CITY OF PORTLAND, MAINE
DEVELOPMENT REVIEW APPLICATION
PLANNING DEPARTMENT PROCESSING FORM

Verrill St Lot 15A

DRC Conditions of Approval

CITY OF PORTLAND, MAINE
SITE PLAN REVIEW (ADDENDUM)
CONDITIONS OF APPROVAL

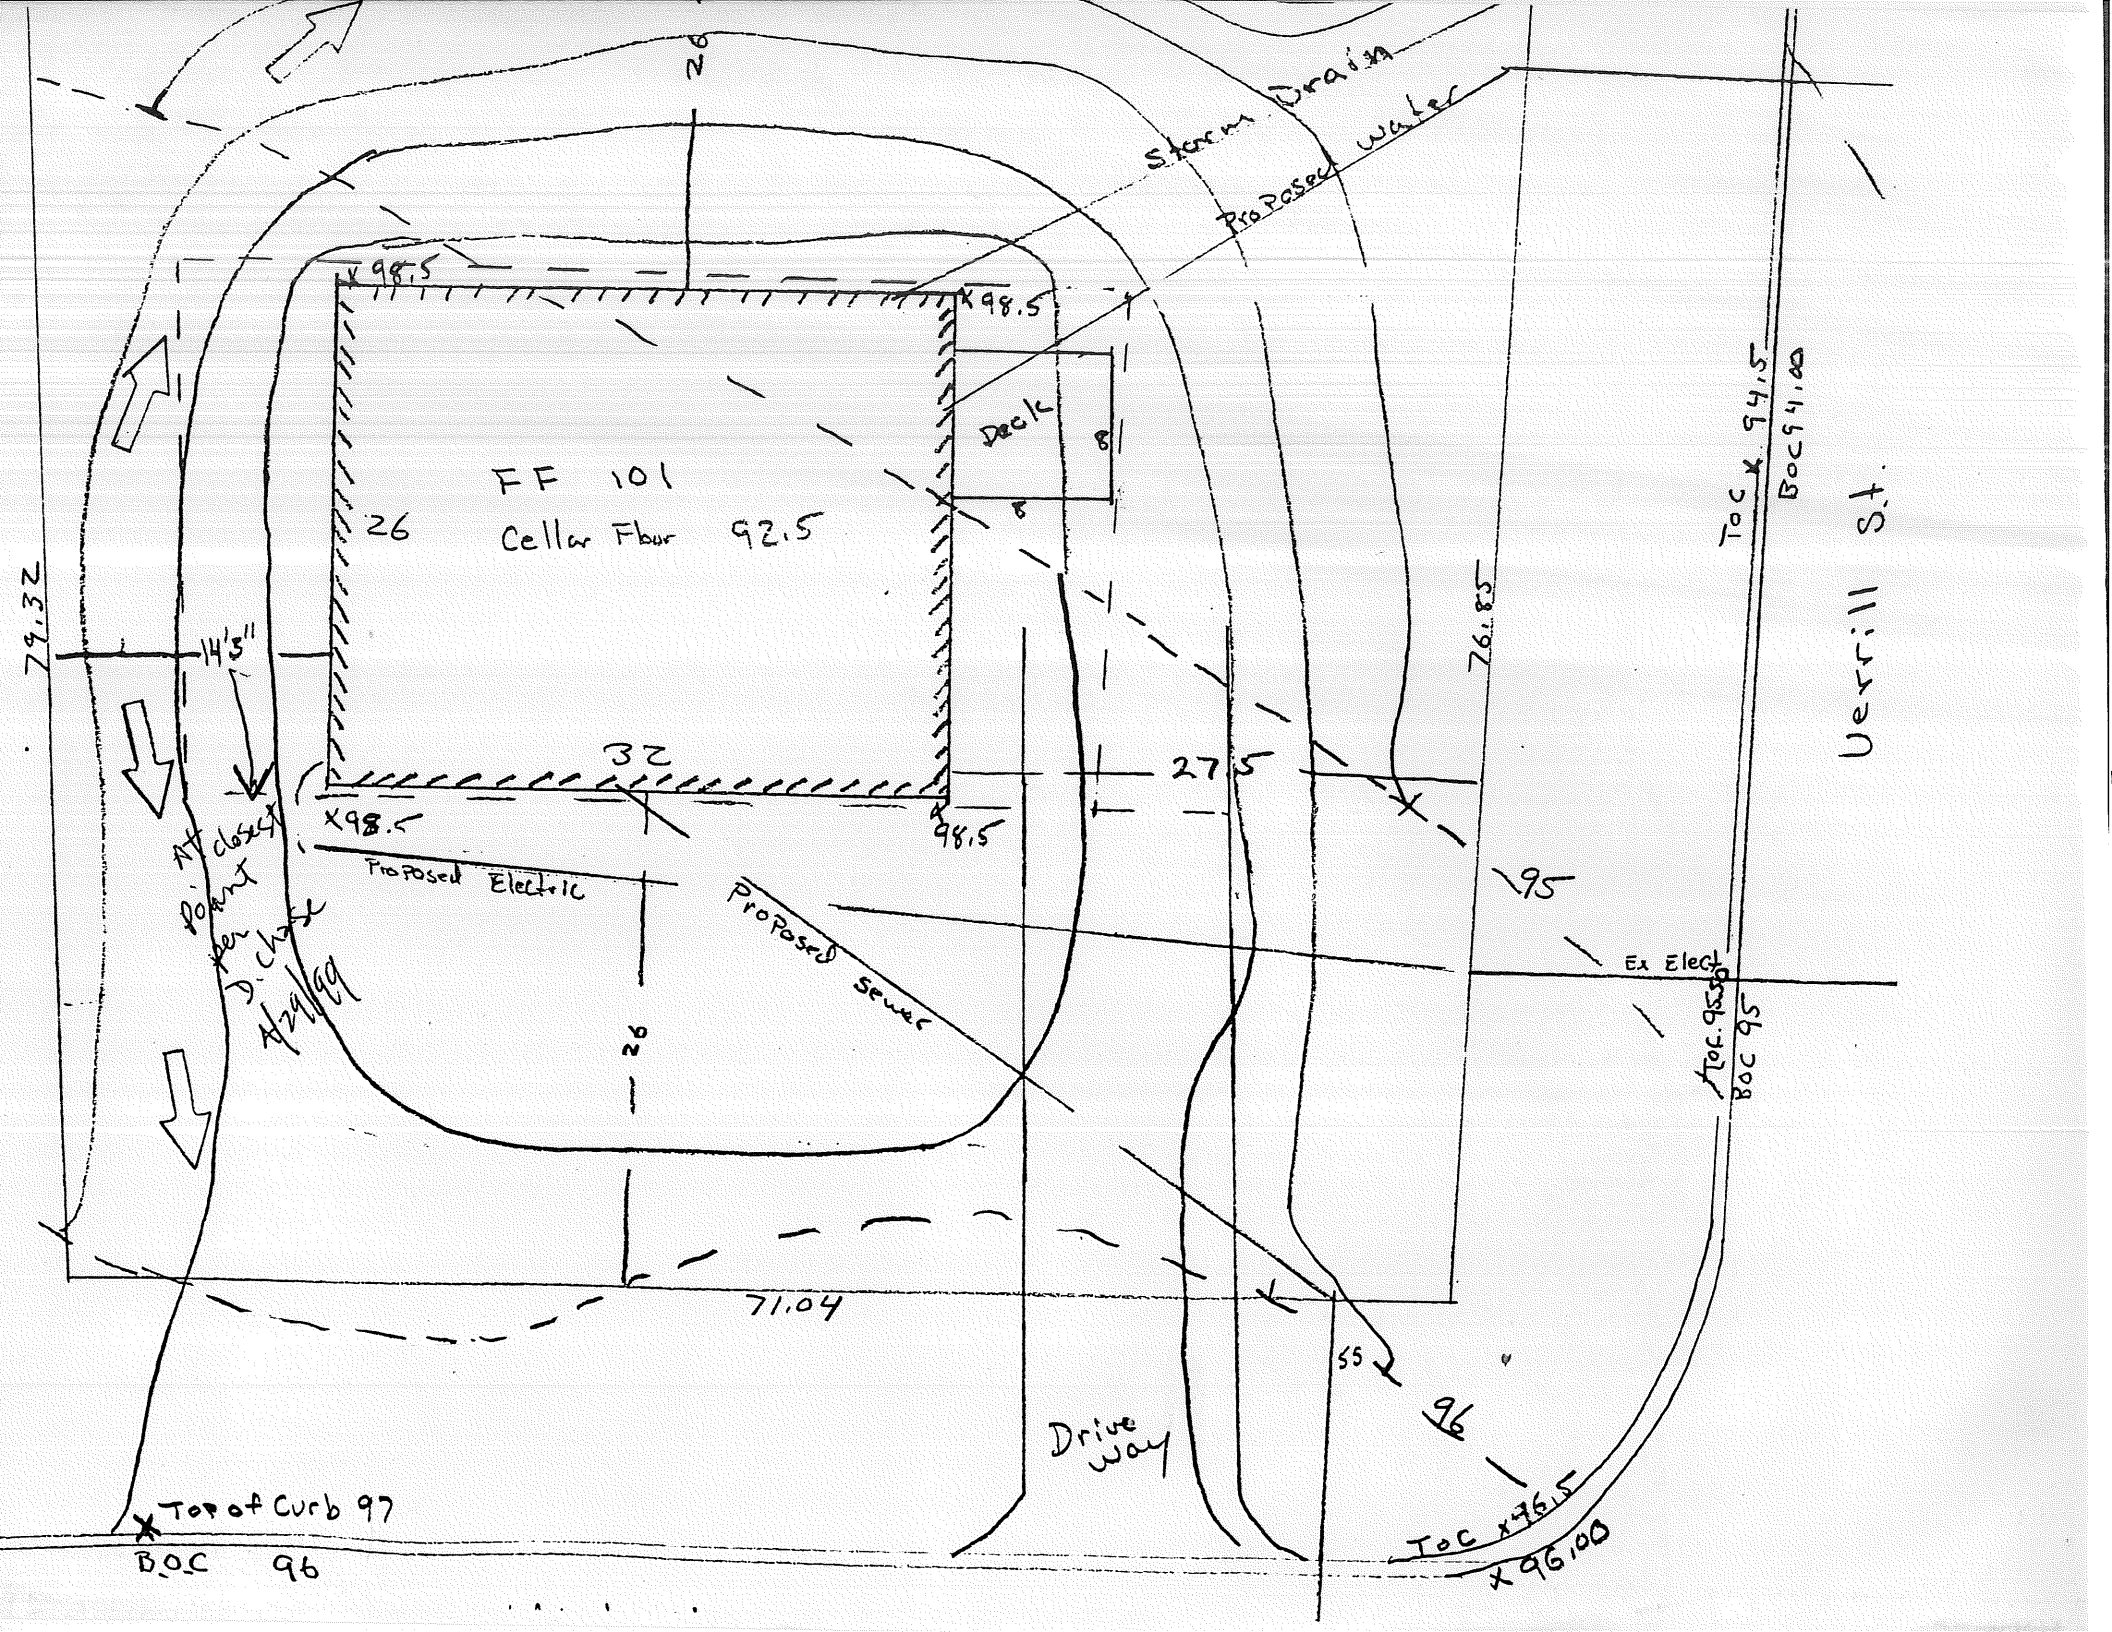
Show all utility connections: water, sanitary, sewer, storm drain, electric, telephone, cable.

A drainage plan shall be submitted to and approved by Development Review Coordinator showing first floor

A swale shall be constructed along the southerly property line such that the drainage is

directed and discharged onto Verrill Street.
